# Technical Response Note

28 March 2024  
Version 0.1  
Draft / Working

Fore Consulting Limited (Fore) is instructed by John Cotton Group Ltd to assist an outline planning application for a proposed warehouse development on the former Cooper Bridge Waste Water Treatment Works, near Mirfield, Kirklees, in respect of transport and highways matters. The commission included the preparation of a Transport Assessment and Travel Plan submitted with the planning application to Kirklees Council<sup>1</sup>.

This note provides a technical response to a consultation by Kirkless Council's Highways Development Management (HDM) team on the planning application, dated 25 October 2023, specifically in relation to points raised regarding the proposed access arrangements. It is structured based on the Council's consultation, for cross-referencing purposes.

3633 100-P-002 B

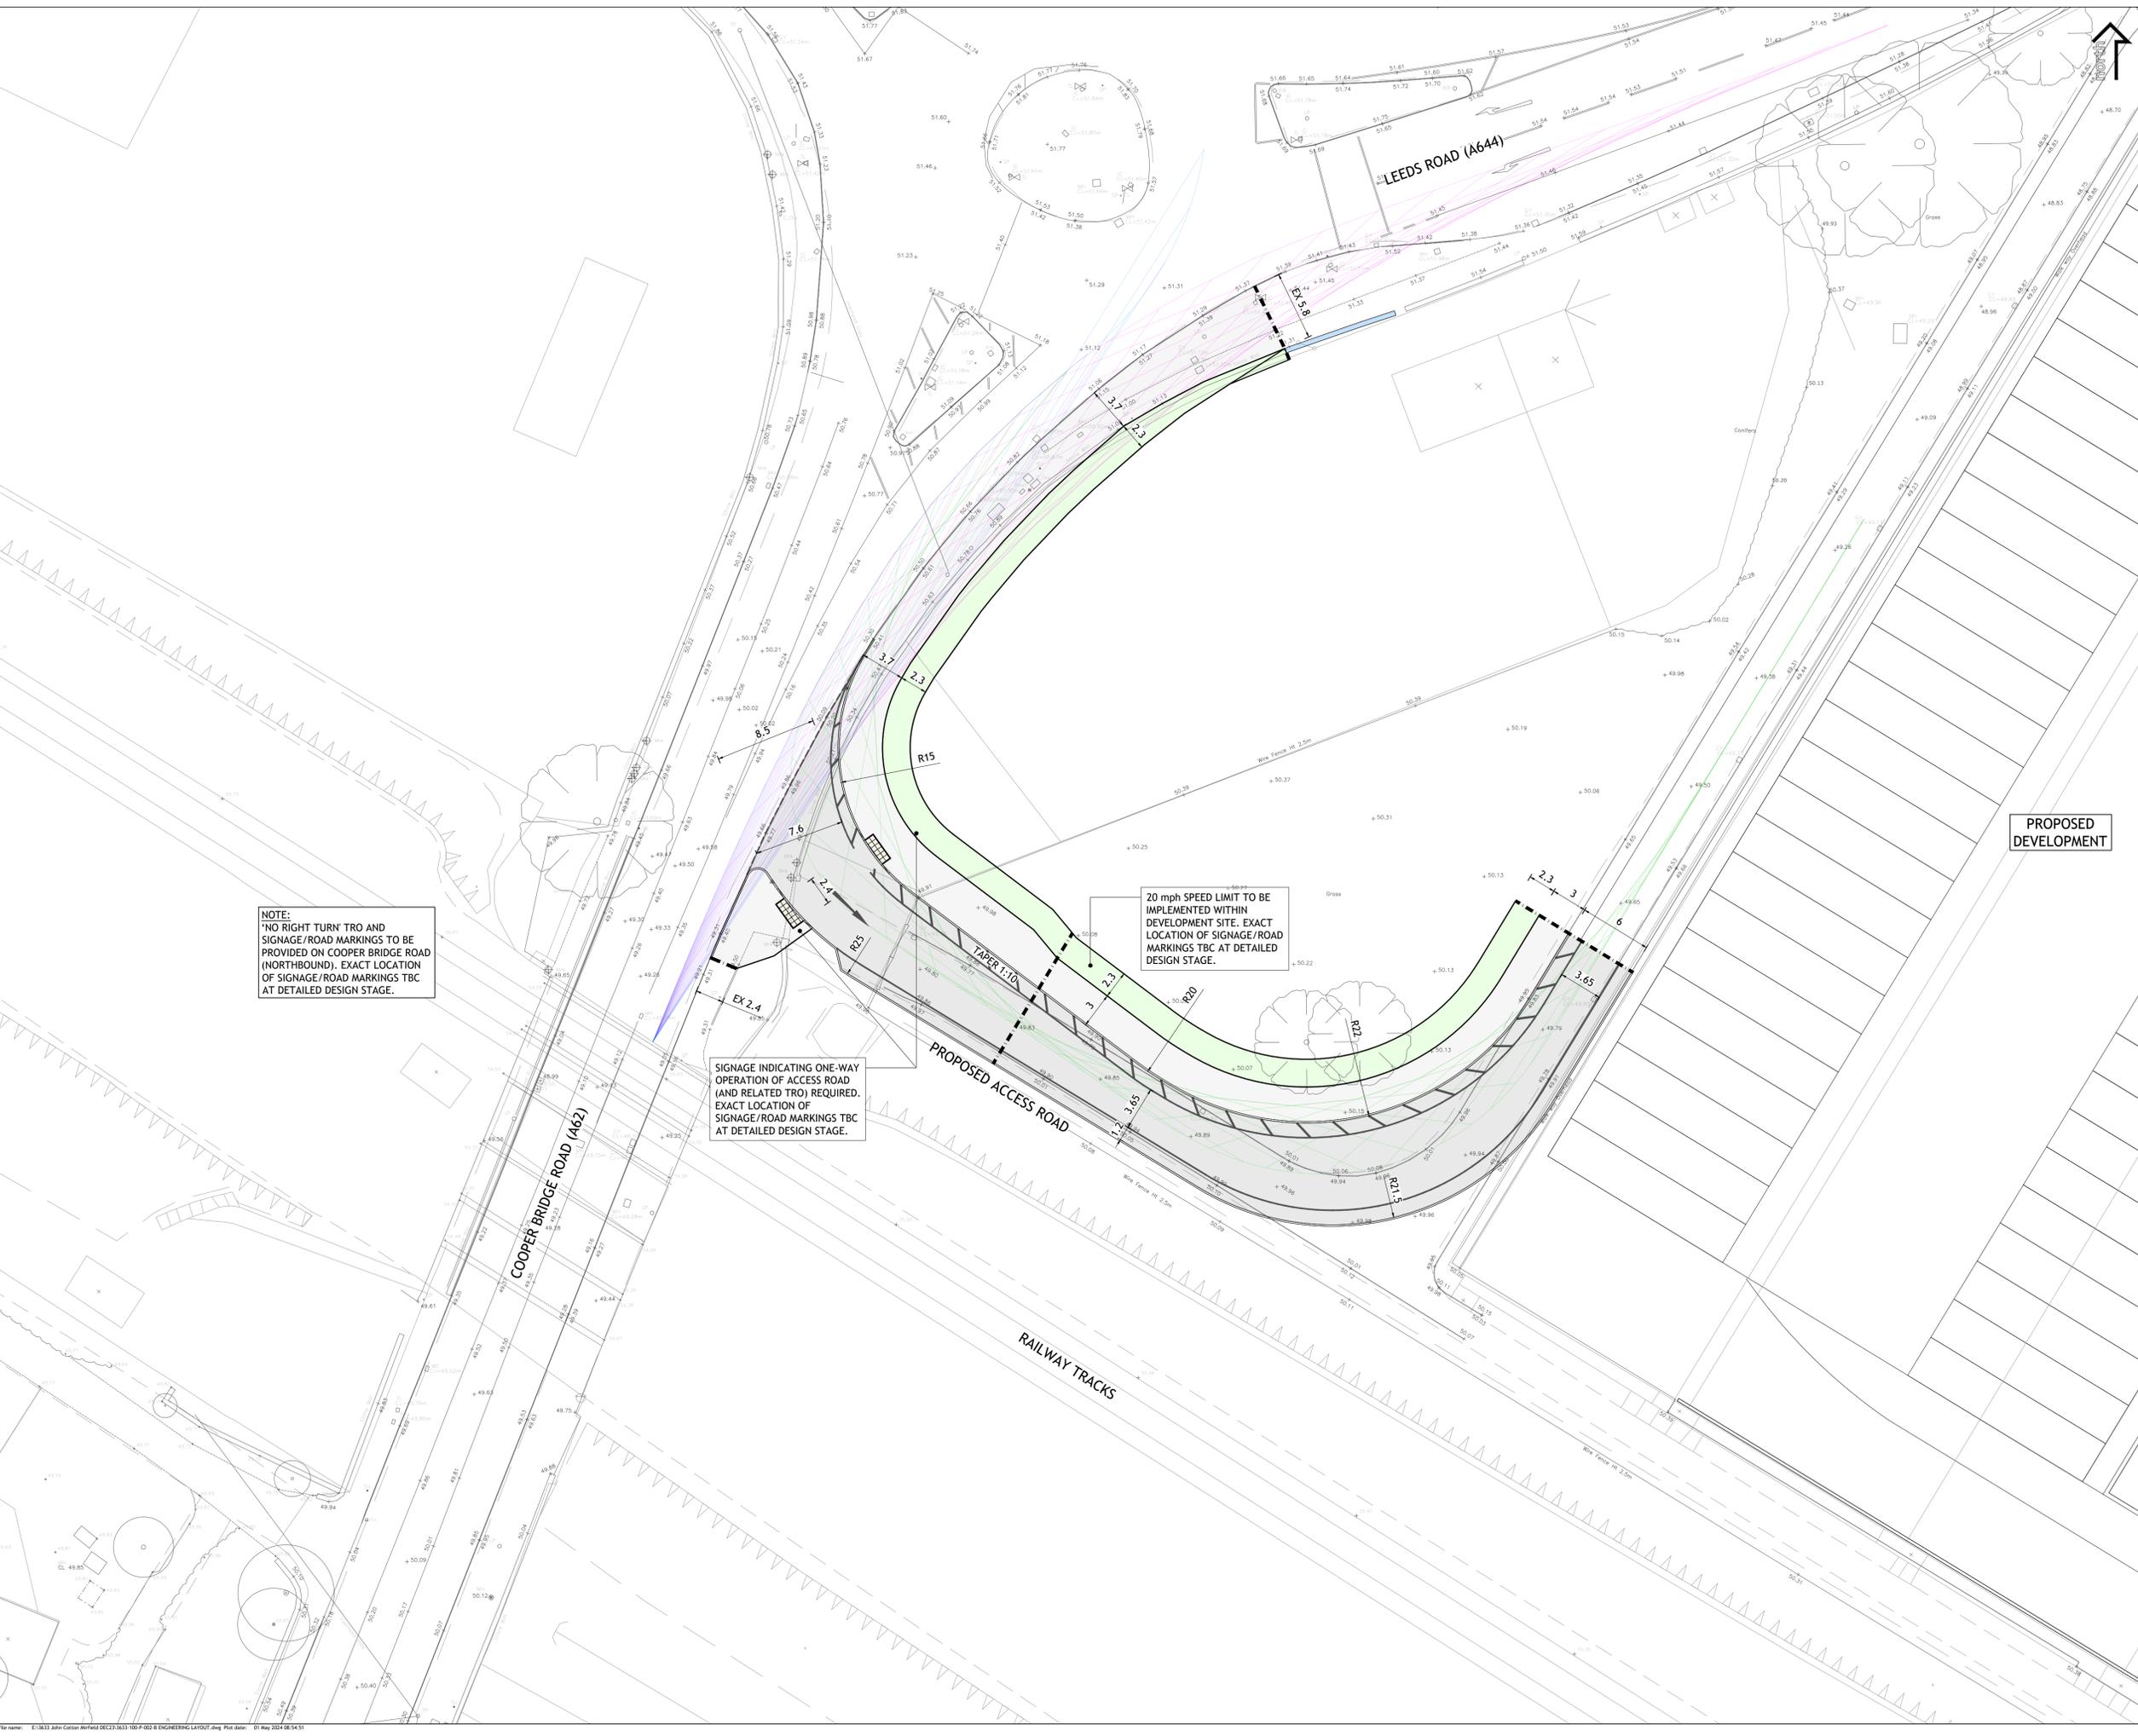
<p><b>Upgraded Access on Huddersfield Road</b></p>	
<p><i>A right turn lane is proposed at the upgraded site access junction on Huddersfield Road, which is proposed to replace the existing hatch markings. However, the layout of the right turn lane is not in accordance with DMRB standards, which includes a lack of adequate deceleration length, storage length, taper and lane width. These deficiencies cannot be addressed due to the location of the adjacent traffic signals, and are significant road safety concerns that could result in rear shunt collisions, late braking and blocking back to the traffic signals.</i></p> <p><i>As adequate right turn lane facilities cannot be provided at the site access, it is suggested that this movement is prevented through the introduction of a physical segregation island, which appears to be achievable for both the interim situation and with the A62 to Cooper Bridge Corridor Improvement Scheme by extending the existing physical island at the signalled junction passed the site access in the existing hatched area. Whilst preventing right turners into this access will alter the access strategy for the development, this arrangement would still enable access to the site, subject to the left in access only on Cooper Bridge Road being achievable and being made available for both HGV’s and staff traffic.</i></p> <p><i>Following consultation with the Councils Road Safety team, significant concerns have been raised regarding right turning</i></p>	<p>Revised arrangements are demonstrated on Fore drawing 3633/100/P010. This comprises an extended physical island on Huddersfield Road to preclude the ability of vehicles to turn right into the site, and allow ‘left in, left out’ movements only. The impact of this on the operation of the existing Cooper Bridge roundabout is assessed in the highway modelling work submitted to the Council under separate cover.</p> <p>Although based on Huddersfield Road as existing, the proposed access arrangement is in line with the arrangements discussed with the Council’s Major Projects team progressing the wider Cooper Bridge Improvement Scheme. It is understood that the proposed access arrangements are to be incorporated in the emerging Improvement Scheme ‘as existing’ based on the likelihood that the development proposed by John Cotton Group Ltd will come forward in advance of the Council’s Improvement Scheme, which is subject to detailed design and preparation of a satisfactory business</p>

<p><i>No details of junction visibility have been confirmed in the Transport Assessment or the supporting plans. However, it is clear that junction visibility to the right on exit of the site access is not in accordance with DMRB requirements (e.g. below 2.4x120m based on 40mph speed limit) and is severely substandard. It is noted that it may be possible to address this issue by setting back the boundary wall in the existing John Cotton site to the east of the access. However, this will have implications on the existing parking area and service yard, and the necessary amendments need to be identified. It is noted that these changes will also require further changes to the planning application red line boundary.</i></p>	<p>An automatic traffic count survey was commissioned to collect traffic speed data over 7 consecutive days commencing Tuesday 30 January. This confirmed 85<sup>th</sup> percentile vehicle speeds of 30.8mph on Huddersfield Road, approaching the proposed access junction. Relating this to DMRB guidance, such speeds equate to a desirable minimum stopping sight distance of 70m.</p> <p>By nature of using 85<sup>th</sup> percentile speeds to establish visibility requirements, it follows that a proportion of vehicles in practice travel faster than the 85<sup>th</sup> percentile speed recorded. Taking into account speeds observed at certain times of day (eg overnight) when traffic flows are lower, and therefore speeds are naturally higher, it is proposed that warning signage to indicate the location of the proposed access is provided. Effectively this mitigates the observed speeds higher than the 85<sup>th</sup> percentile, and allows visibility to be provided a level that is 'one step below the desirable minimum'.</p> <p>The resulting visibility splays of 2.4m x 70m are achievable within the existing extent of public highway and land controlled by the applicant.</p>

Kirklees Council Comment	Fore Response
<p><i>The site access plans do not currently acknowledge the existing cycle lanes on Huddersfield Road, or provide suitable arrangements for pedestrians and cyclists, which must be incorporated into the design.</i></p>	<p>The revised arrangements incorporate the existing cycle lanes on Huddersfield Road around the proposed access. Cyclists approaching from the east have the option of using the proposed access road to access the development, and cyclists approaching from the west (via Cooper Bridge Road) and north (via Leeds) would have the option of using the Cooper Bridge Road access, which provides a suitable route to the development.</p>
<p><i>The only feasible option appears to be a left in/left out priority junction (or alternatively a fully signalised junction could be considered, although traffic capacity issues are likely to preclude this as an option). Updated plans are required of these revised access proposals, which should be fully dimensioned and include swept path analysis (SPA) of HGV's that have been undertaken at an appropriate design speed (to be confirmed in the SPA report).</i></p>	<p>The revised arrangements and details requested are demonstrated on Fore drawing 3633/100/P010.</p>

Drawing Title:
SITE ACCESS ENGINEERING LAYOUT

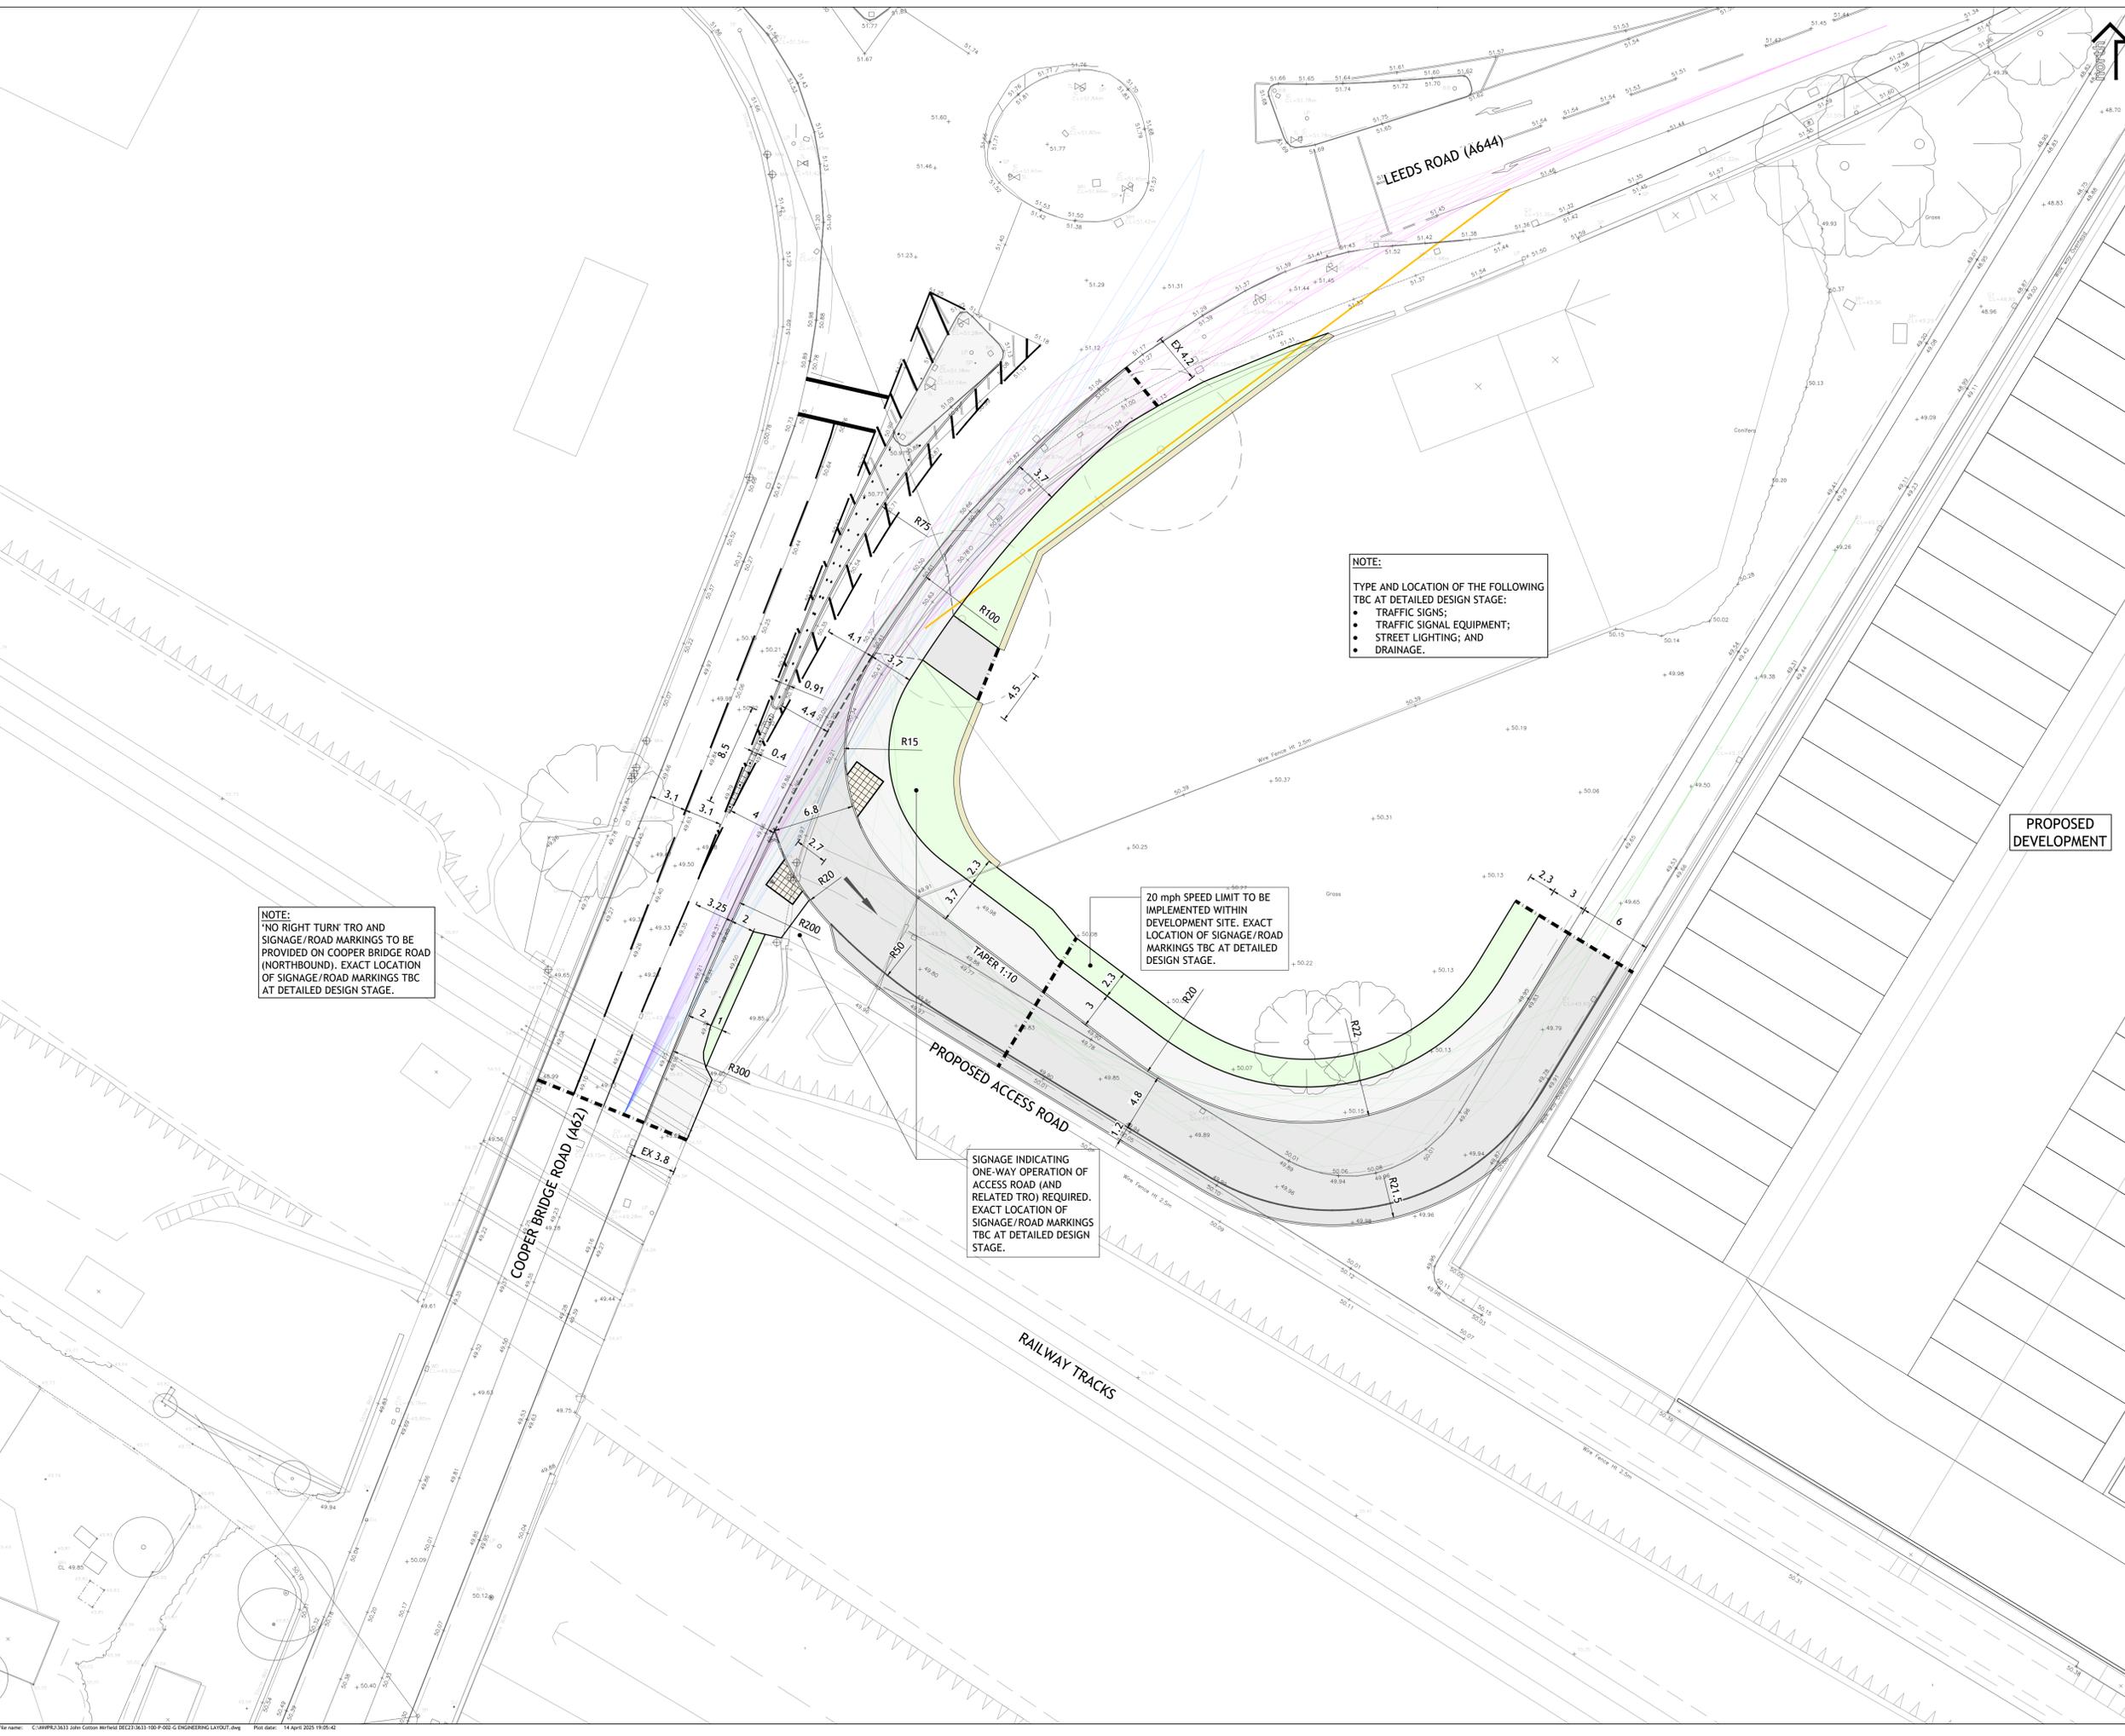
Kirklees Council Comment	Fore Response
<b>In Only Access on Cooper Bridge Road</b>	
<p><i>The proposed entry only access on to Cooper Bridge Road may be acceptable in principle. However, inbound right turn movements are not acceptable at this access for safety/operation reasons; and are likely to result in rear shunt incidents associated with the lack of any right turn lane facilities, as well as right turning incidents associated with the close proximity of the signalised roundabout to the north.</i></p> <p><i>These problems would be further exacerbated once the A62 to Cooper Bridge Corridor Improvement Scheme is delivered, which are currently envisaged to include two southbound lanes on Cooper Bridge Road. Therefore, only a left in access could be accepted in this location, which would require any northbound development traffic on Cooper Bridge Road to circulate Cooper Bridge Roundabout (or the revised gyratory system currently being developed) before entering via this access.</i></p> <p><i>As only left in access could be accepted, physical measures to prevent right turn movements into the site access should be provided. However, as there are width constraints on Cooper Bridge Road that will not allow this in the interim situation (a separation island can be implemented later with the A62 to Cooper Bridge Corridor Improvement Scheme), the only physical measures that are likely to be possible in the interim situation would relate to the alignment of the access to discourage right turn movements, and in particular HGV's, which must be incorporated into the proposals.</i></p>	<p>Noted and accepted.</p> <p>The proposed arrangements have been amended to discourage right turn manoeuvres into the access, as far as practicable.</p> <p>The arrangements are demonstrated on Fore drawing 3633/100/P001A accordingly.</p> <p>Although based on Cooper Bridge Road as existing, the proposed access arrangement is in line with the arrangements discussed with the Council's Major Projects team progressing the wider Cooper Bridge Improvement Scheme. It is understood that the proposed access arrangements are to be incorporated in the emerging Improvement Scheme 'as existing' based on the likelihood that the development proposed by John Cotton Group Ltd will come forward in advance of the Council's Improvement Scheme, which is subject to detailed design and preparation of a satisfactory business case (as part of the WYCA approvals process for release of funding).</p>

<p><i>To further discourage right turn movements into this site access, it is suggested that a 'no right turn' TRO and signage/markings are provided on Cooper Bridge Road. Based on HDM's initial discussions with their counterpart at Calderdale Council, it was considered that in principle a TRO of this type may be acceptable in this situation.</i></p>	<p>Provision for such a TRO and related signage is indicated within the revised arrangements.</p>
<p><i>Whilst a left in access on Cooper Bridge Road may be acceptable in principle, the arrangements currently proposed are unacceptable. The access must be designed in accordance with DMRB standards, which require (see 5.6.2 of CD 123) 15m corner radii, with a corner taper of 1:10 over a distance of 25m on the minor arm, to ensure that HGV's traffic can turn left at an appropriate design speed, without causing rear shunt type incidents. In addition to these junction geometry requirements, right turn movements into the access need to be actively discouraged as mentioned above. The minor arm of the site access also needs to be of sufficient width to allow an inbound HGV's to pass a stationary vehicle (either parked or broken down), to ensure that blocking back onto the highway does not occur</i></p>	<p>The revised arrangement incorporates the identified provisions.</p> <p>The minor arm is widened to 6.0m width, to allow vehicles to pass should this be necessary. The swept path of passing vehicles in this way is demonstrated on Fore drawing 3633/100/P003A.</p>

<p><i>In light of the above, significant changes are required to the Cooper Bridge Access arrangements, which must be designed to work with the current highway arrangements and the future A62 to Cooper Bridge Corridor Improvement Scheme. Updated plans are required of these revised access proposals, which should be fully dimensioned and include swept path analysis (SPA) of HGV’s that have been undertaken at an appropriate design speed (to be confirmed in the SPA report).</i></p>	<p>The revised arrangements and details requested are demonstrated on Fore drawings 3633/100/P001A to and 3633/100/P003A.</p> <p>Swept path analysis assumes a vehicle speed of 30mph, reducing to 20mph when passing a vehicle parked on the access road Such speeds are suitable given the nature of the proposed access road.</p>
<p><i>Subject to an acceptable access arrangement being demonstrated in principle, these arrangements will then need to be agreed with Calderdale Council as Local Highway Authority for this section of Cooper Bridge Road, and a Stage 1 Road Safety Audit and Designers Response will be required. Prior to undertaking any Stage 1 RSA, an RSA Brief will need to be agreed by both highway authorities.</i></p>	<p>Noted. Confirmation is requested that the proposed arrangements are accepted for the purposes of a Stage 1 RSA.</p>
